From: Michael Eastham
Sent: 20 October 2017 18:59
To: Planning.Responses
Subject: FW: Saltbox, Bognor Regis - Heads of Terms

From: Nia Russell [REDACTED]
Sent: 20 October 2017 15:13
To: Michael Eastham
Subject: Re: Saltbox, Bognor Regis - Heads of Terms

From: Nia Russell [REDACTED]
Sent: 20 October 2017 11:35
To: Michael Eastham
Cc: Arfon Hughes
Subject: Re: Saltbox, Bognor Regis - Heads of Terms

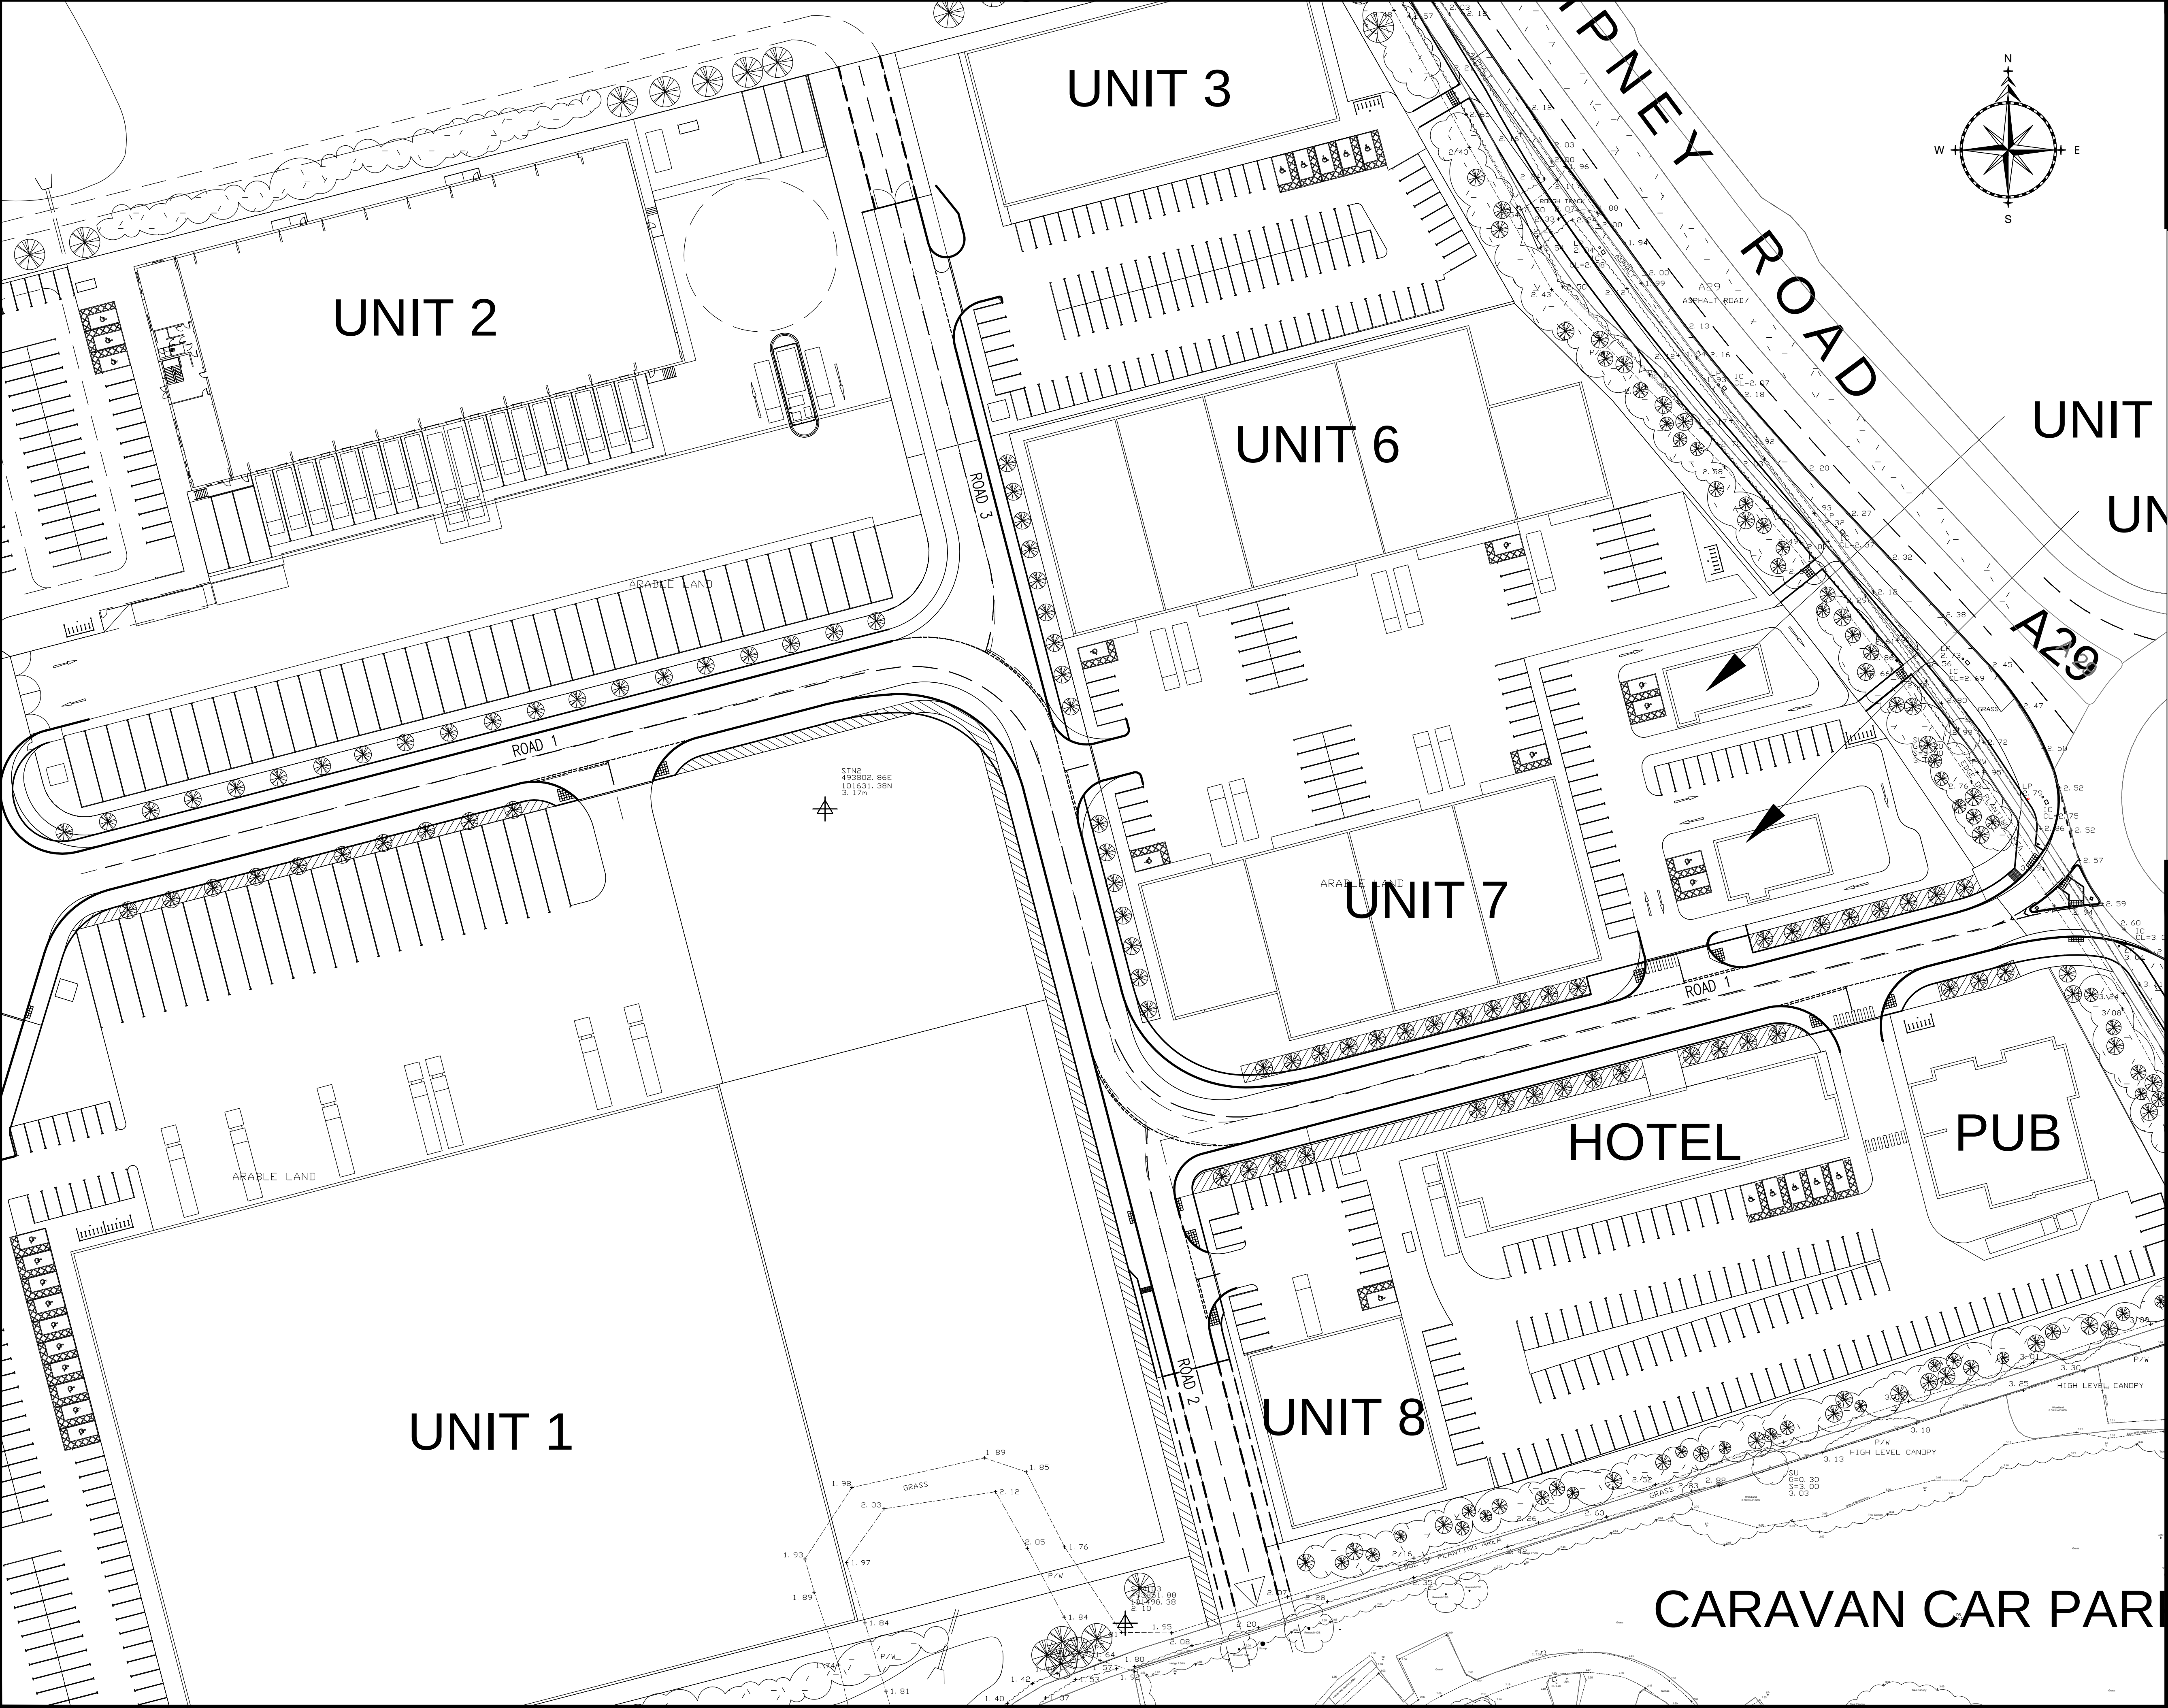
Michael, just to conclude matters, I would confirm that all outstanding matters have now been addressed. In saying this, I can't see a copy of the drawing showing the revised spine road arrangement (drawing no. H1194-201, dated 22nd September 2017) on the planning file. I presume this has been submitted to you and will form part of the package of approved drawings.

No part of the development shall be first occupied until such time as the vehicular access onto A259 Felpham Relief Road Roundabout has been constructed in accordance with the details indicatively shown on drawing no. H1194-201.

Please find attached a copy of H1194-200 Rev A which was amended to address comments from WSCC regarding the width of the estate road which we adjusted to allow two HGV's to pass without conflict on the bends.
